**WELWYN HATFIELD BOROUGH COUNCIL
EXECUTIVE DIRECTOR - PLANNING, PUBLIC PROTECTION AND GOVERNANCE**

DELEGATED APPLICATION

Application No: 6/2017/2746/LB
Location: Comet Hotel St Albans Road West Hatfield AL10 9RH
Proposal: Extension and refurbishment of the Grade II listed building (Use Class C1) following demolition of existing rear and side extensions. Erection of student accommodation (Sui Generis) with landscaping and associated works.
Officer: Mrs June Pagdin

Recommendation: Granted

DRAWING TITLE  
Demolition Listed Building Floor Plans

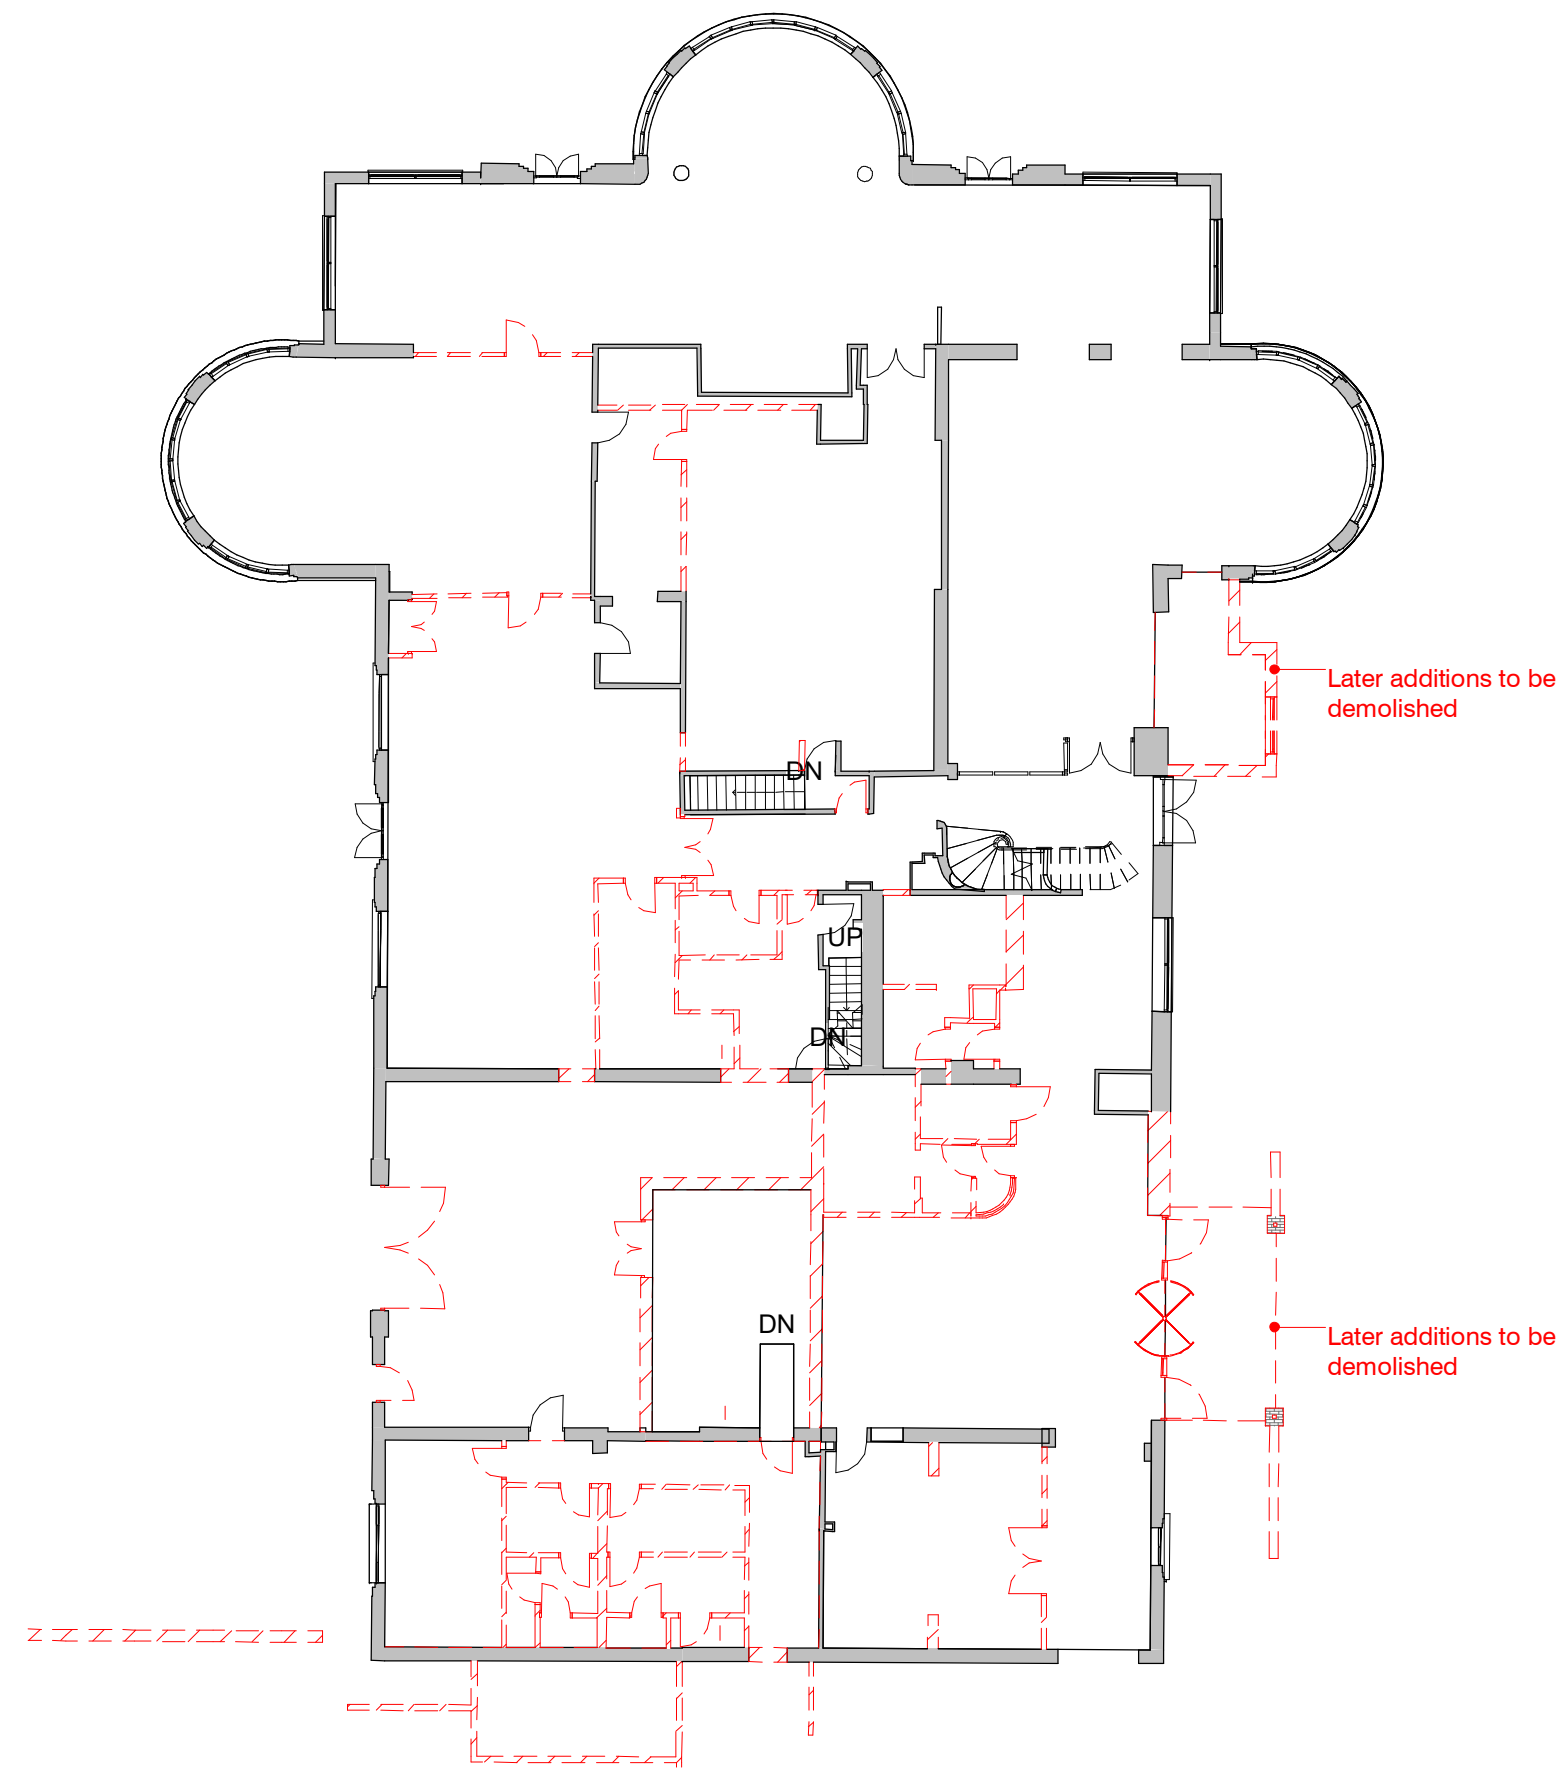
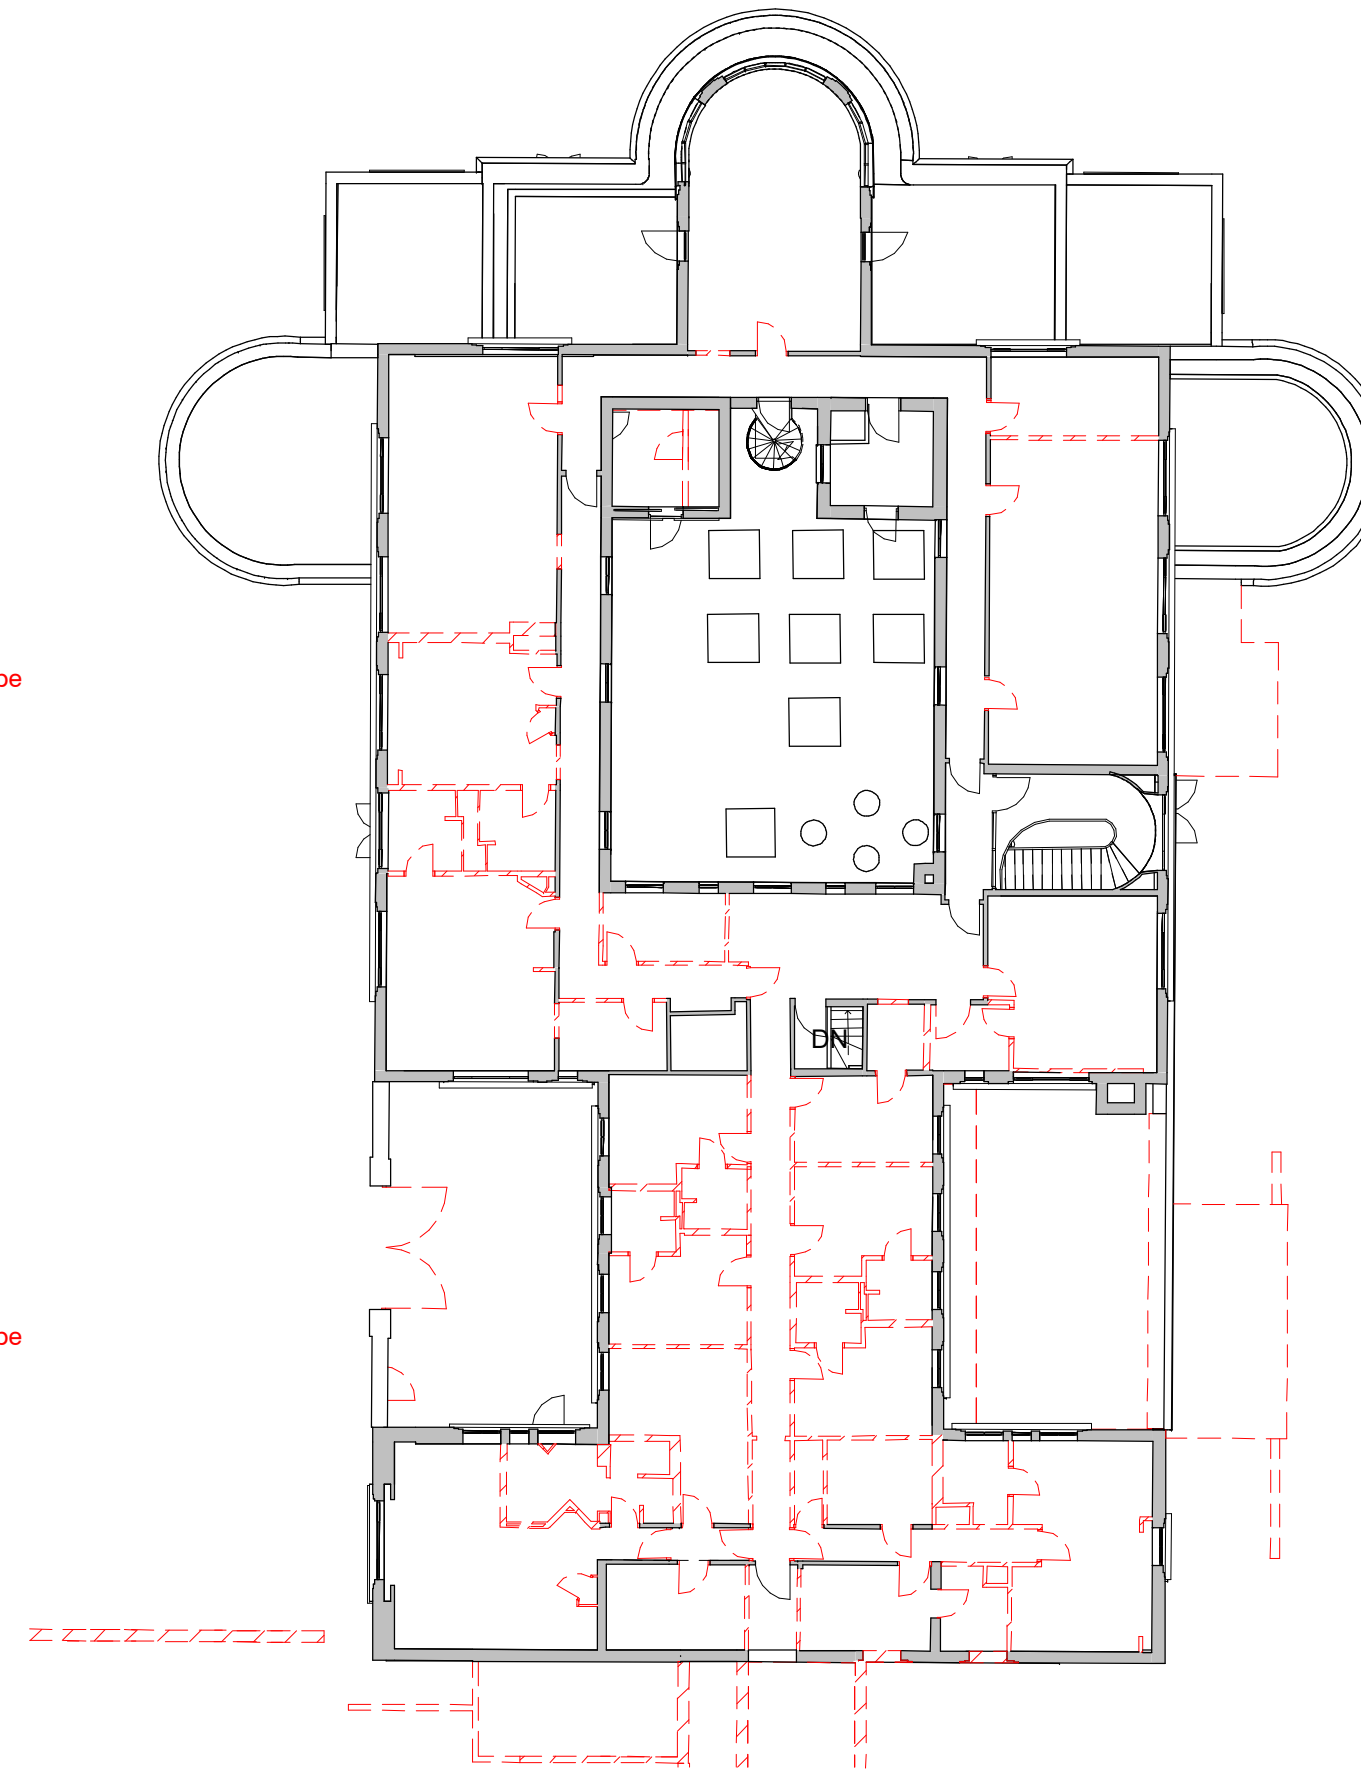
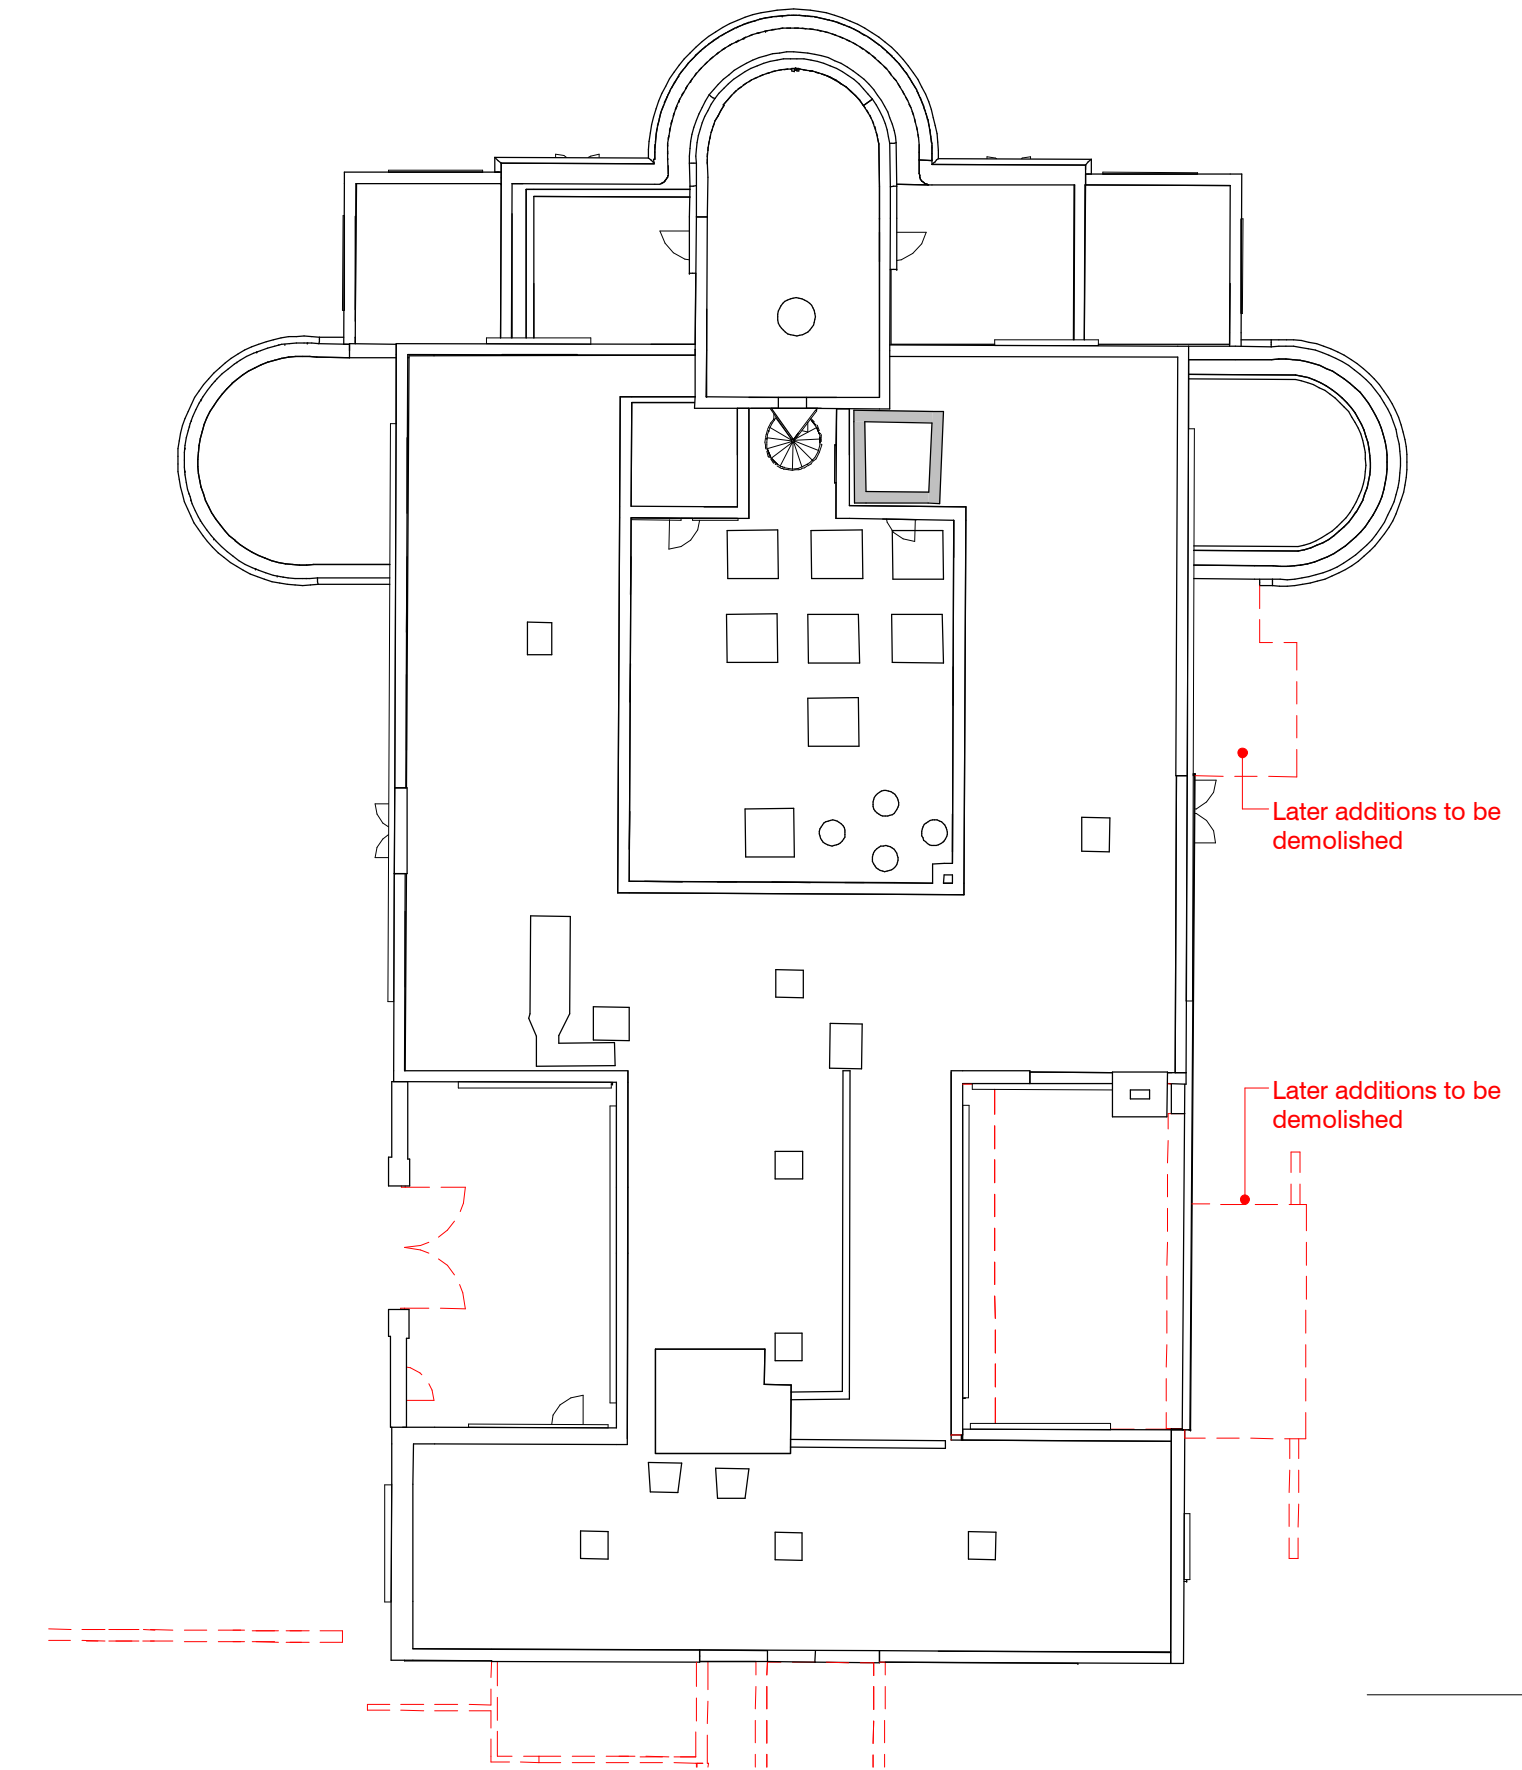
The Heritage Advisor comments that the removal of surviving partition walls and the nibs of former partitions in the rear of the building where the garage and chauffeur quarters historically were would compromise the understanding of the historic plan form. It is recommended that nibs are retained as part of the scheme and exploration of this can be secured by condition.

- a) reinstatement of roof lantern (elevations at scale 1:20 and sections at 1:50);
 - b) retention of nibs to walls in the rear part of the listed building which were previously the chauffeur and garage quarters (floor plans at scale 1:50);
